**FORMAL REPRESENTATION: OBJECTION TO PLANNING APPLICATION
2026/91923**

Land at St Luke's, Bierley Marsh, East Bierley, BD4 6PL

Objection – failure to comply with the Kirklees Highways Design Guide SPD (2019), the Kirklees Housebuilders Design Guide SPD (2021) and current national highway design guidance

client name		Owens Developments Ltd	
project		New Dwellings - Land at St Lukes.	
drawing		Proposed Site Layout	
project number	19/157		plot date
			24/11/20
drawing number	104		scale
			1:200 @A2
drawing number	rev	issue status	
	J	Planning Submission

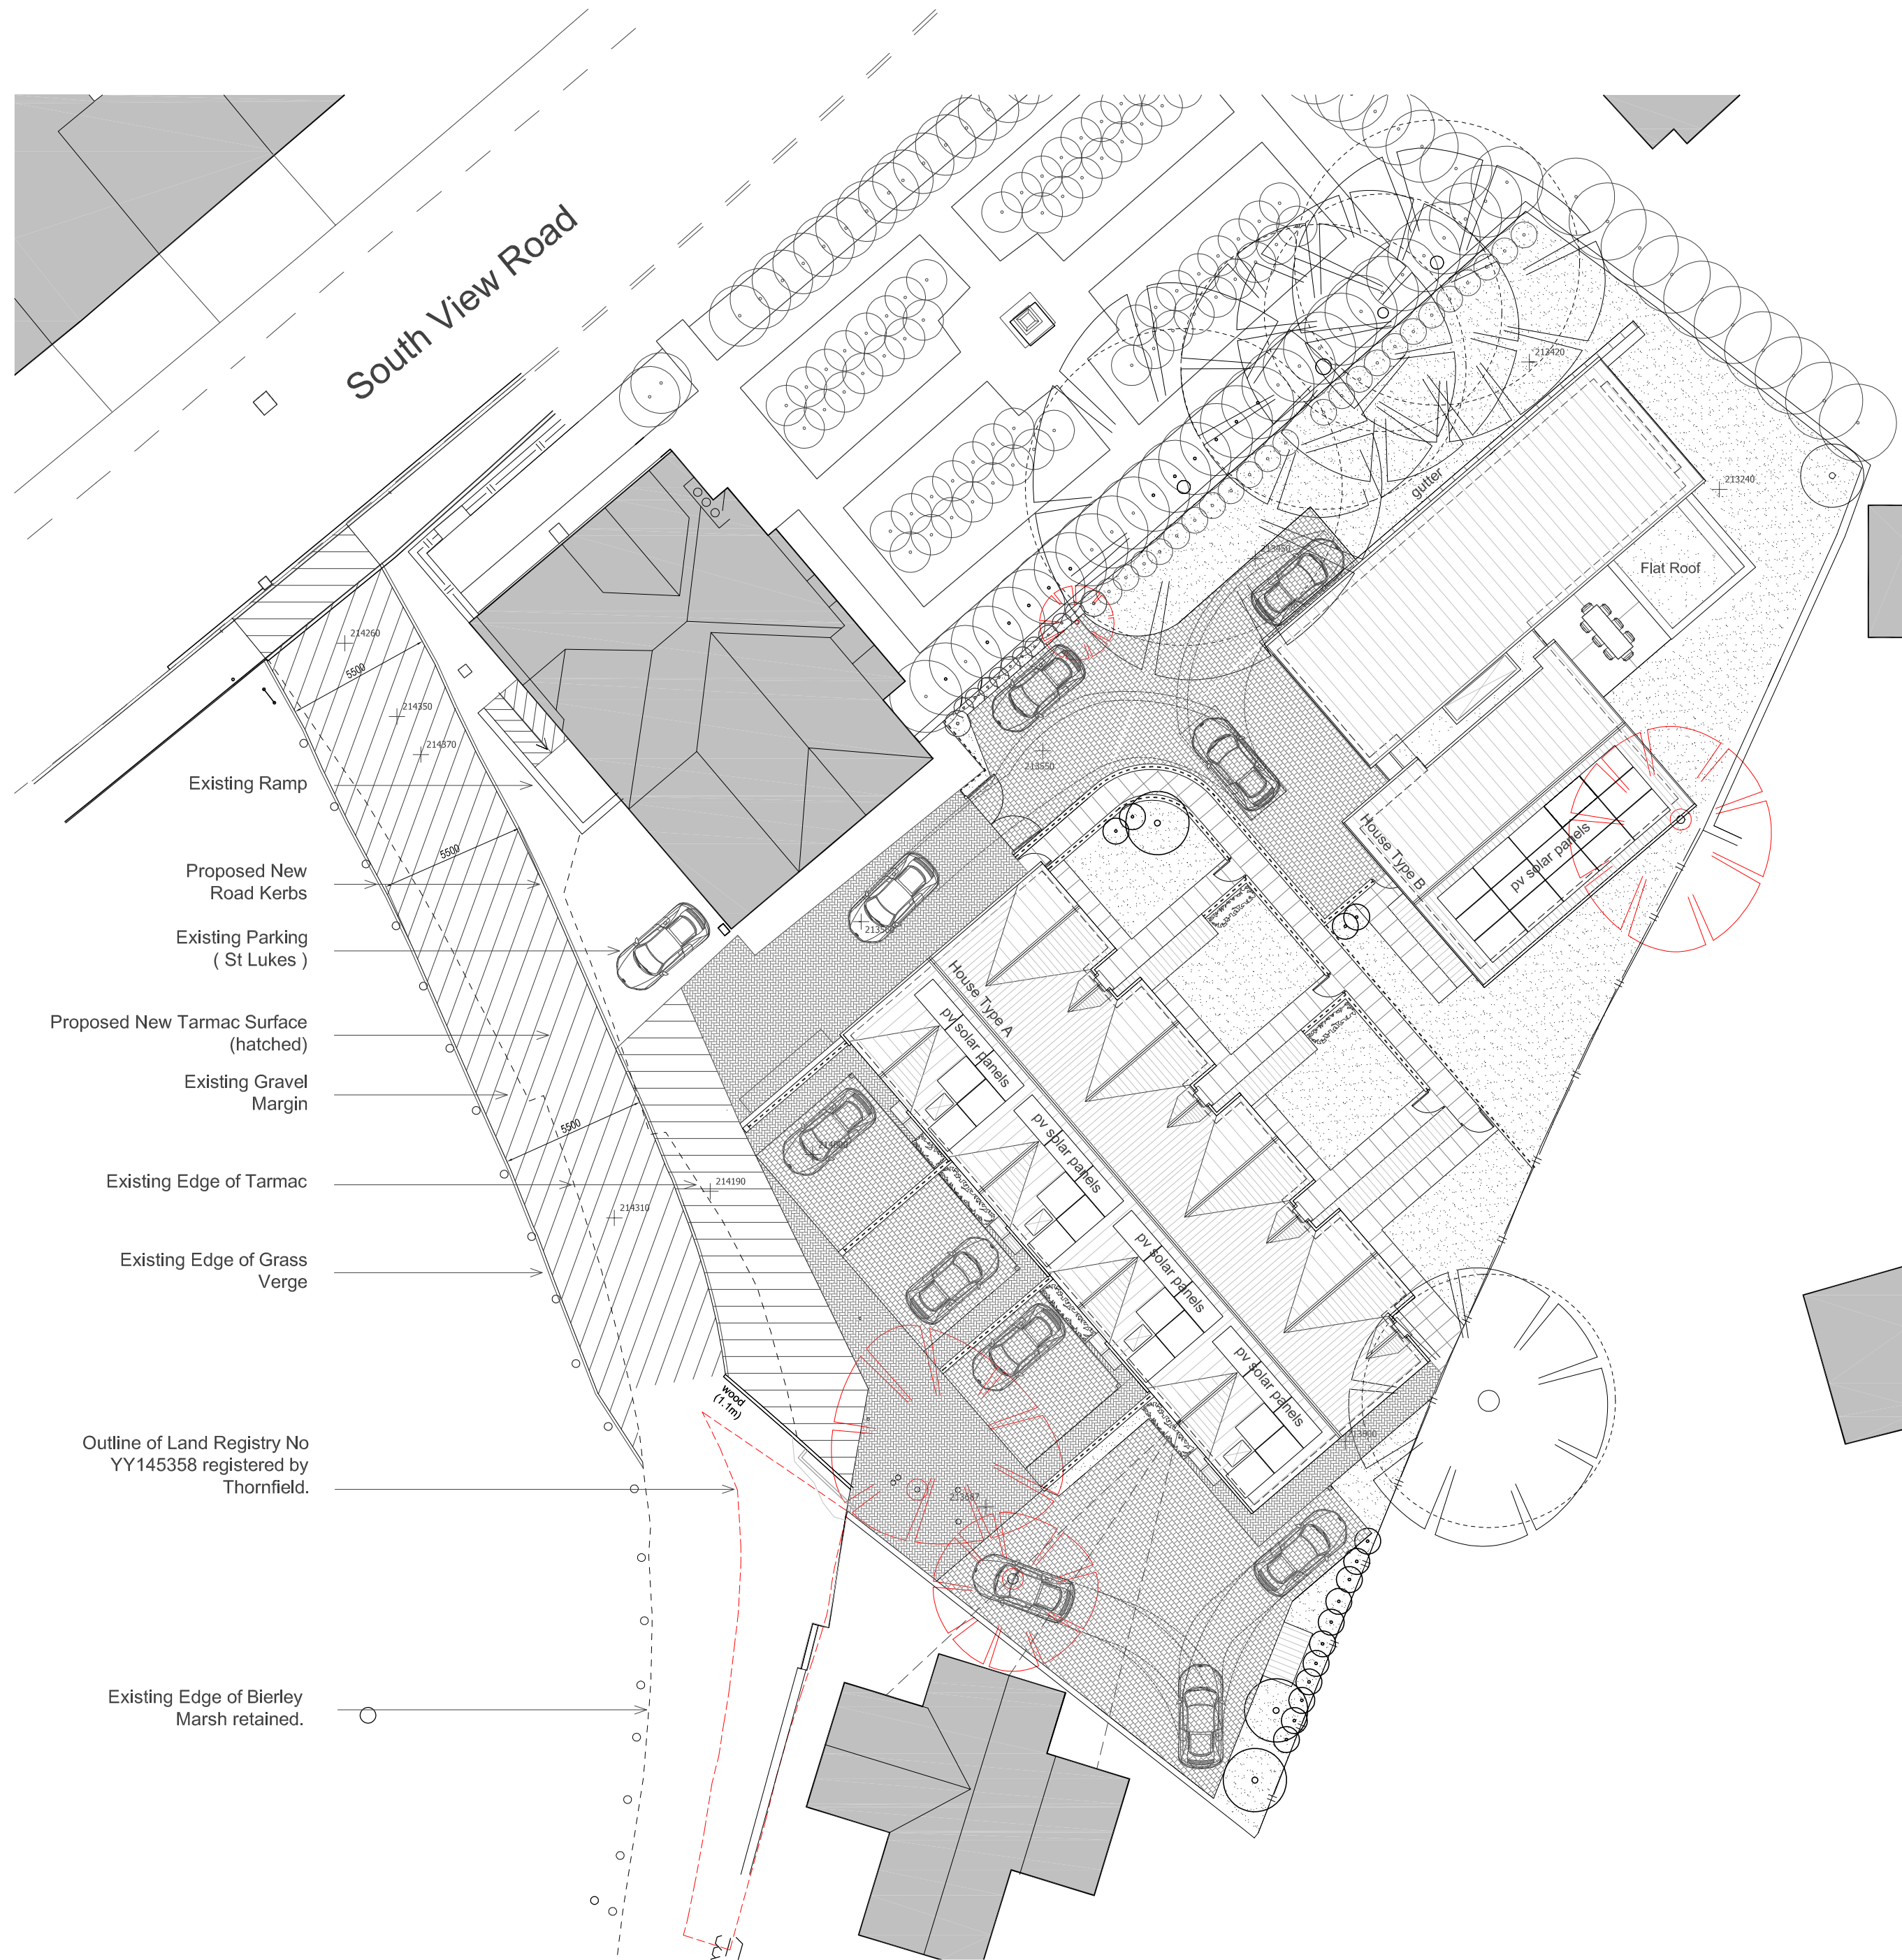
As set out in section 3 below, the applicant has previously sought approval for an access arrangement that removed the highway improvements required for this site, and that approach was found unacceptable by Kirklees Highway Development Management. In my assessment, plan 19-157.104J still does not secure those improvements to the standards.

Plan 19-157.104J appears, on the evidence available, to be a further iteration that similarly does not secure those improvements to the standard the SPD's require (see sections 4–6 below).

These matters, in my view, are not addressed in the submitted application. No long-term maintenance plan has been submitted for the access, notwithstanding that Bierley Marsh also carries a public footpath (SPE/6/20) and will need to accommodate a materially intensified level of use (see section 7 below).

Table 1 sets minimum standards for a Shared Surface Street (Type C), including a 5.5m carriageway and, where applicable, a 0.6m hard margin on both sides. The submitted plans do not, in my assessment, show the required 0.6m hard margin to either side of the proposed 5.5m carriageway. Different plans and consultation comments associated with this application inconsistently record the carriageway as 5m wide, which in my view is evidence that the access has not been designed to a settled, compliant standard.

Section 1.7 of the SPD requires shared space proposals to create a clear “gateway” into the shared space, incorporate guidance paths for pedestrians, manage vehicle speed to 10–15mph, and use tactile paving and other measures to highlight pedestrian crossing points. No such measures are shown or described in the application. There is no segregation between vehicles and pedestrians anywhere on the proposed access, contrary to the priority that both the SPD and NPPF paragraph 117(a) require to be given to pedestrians.

- **Pedestrian and cycle priority (Principle 10, section 7.7):** site access must “prioritise the needs of people walking and cycling” with routes that are “safe, convenient, direct and accessible.” The submitted scheme provides no segregation between vehicles and pedestrians on a shared access that, on the figures set out in section 7 below, will see a substantial increase in vehicle movements.

- formally re-consult Highway Development Management on plan 19-157.104J and place their written response on the public file before determination;
- require the developer to submit a scheme showing full compliance with SPD sections 3.15–3.19 and Table 1, including the 0.6m hard margins and a settled, unambiguous carriageway width;

- require submission and approval of a long-term maintenance plan for the access, secured by planning conditions or legal agreement, before any access-related works commence;
- require the applicant to demonstrate a lawful private right of vehicular access over public footpath SPE/6/20 sufficient to implement the proposed means of access, before the application is determined;
- confirm the current discharge status of condition 5 of appeal ref. APP/Z4718/W/21/3289729;
- require an independent assessment of the impact of the projected increase in traffic on users of public footpath SPE/6/20, with appropriate mitigation secured by condition; and
- Show position and details relating to bin storage and refuse collection.
- refuse the application, or defer determination, until the above matters are resolved to the satisfaction of Highway Development Management.
